[REDACTED] Dean Chapman [REDACTED]
Subject: Objection to 20/00934/FUL

Mrs Oorlagh Chapman
Mr Dean Chapman
Yew Tree Cottage
1 Sandford Road
OX4 4PU

Commenter Type: Neighbour
Stance: Objection

Land to rear of George Pub Littlemore	Date:	01/10/2020
KJD Investments	Scale:	1:100@A3
Units 6 & 7	Status:	Preliminary
Proposed Elevations	Drawn:	JR
190277 - A - 05 - 203	Revision:	C

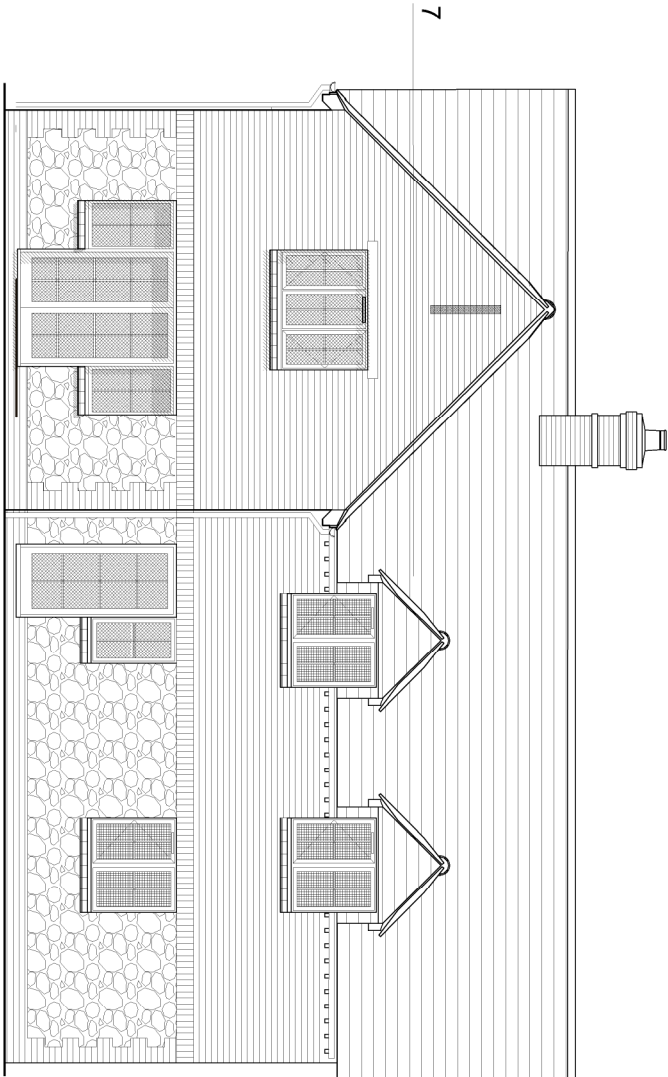
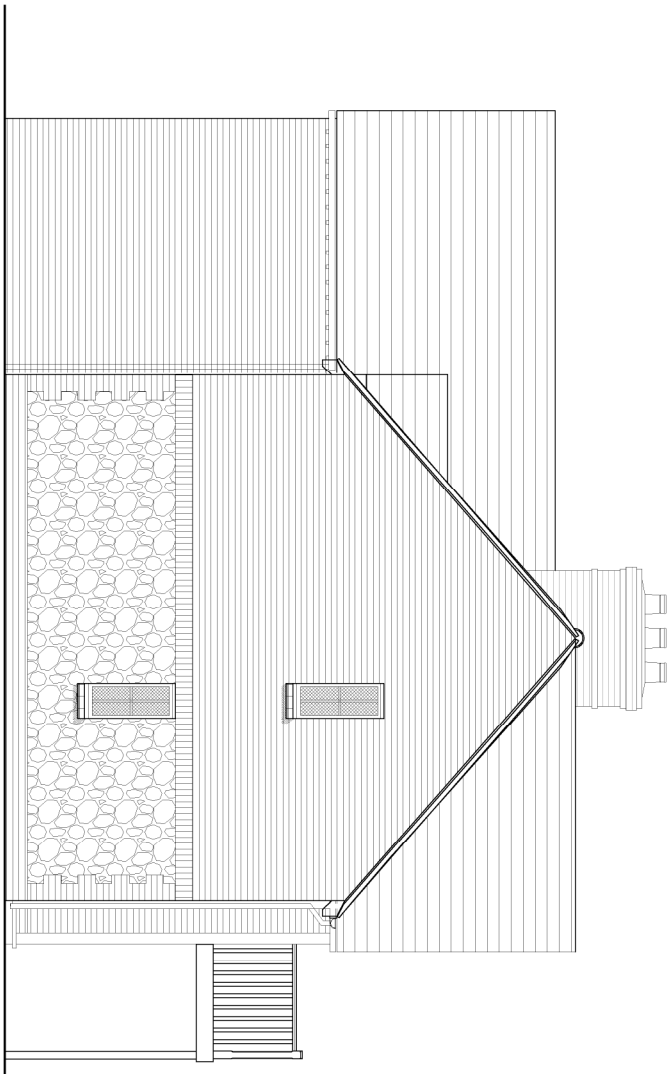
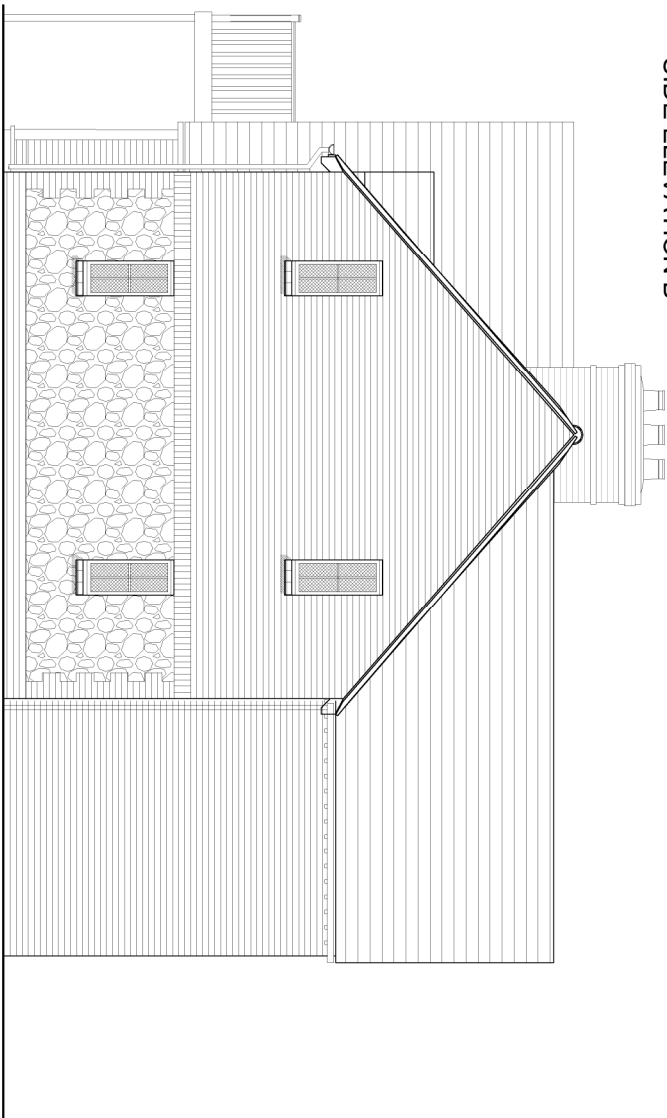
The amendments to the proposed site plan of 25th January is now breaching the right to light by the extension of property 6 on our home – Number 1 Sandford Road. I have provided the below site plans as evidence. Also the revised plans now have windows overlooking our property allowing direct sight in to our home compromising our privacy.

- Loss of light or overshadowing (this isn't just a high wall – it means loss of light to the extent that you don't get enough natural daylight to see by). The revised plans have moved the right to light line and have limited the light to our property.
- Overlooking/loss of privacy – new plans have windows placed looking directly into our property.
- Adequacy of parking/loading/turning
- Highway safety
- Traffic generation
- Layout and density of building
- Proposals in the Development Plan
- Over-development or overcrowding of the site to the detriment of all neighbouring properties and the area as a whole.
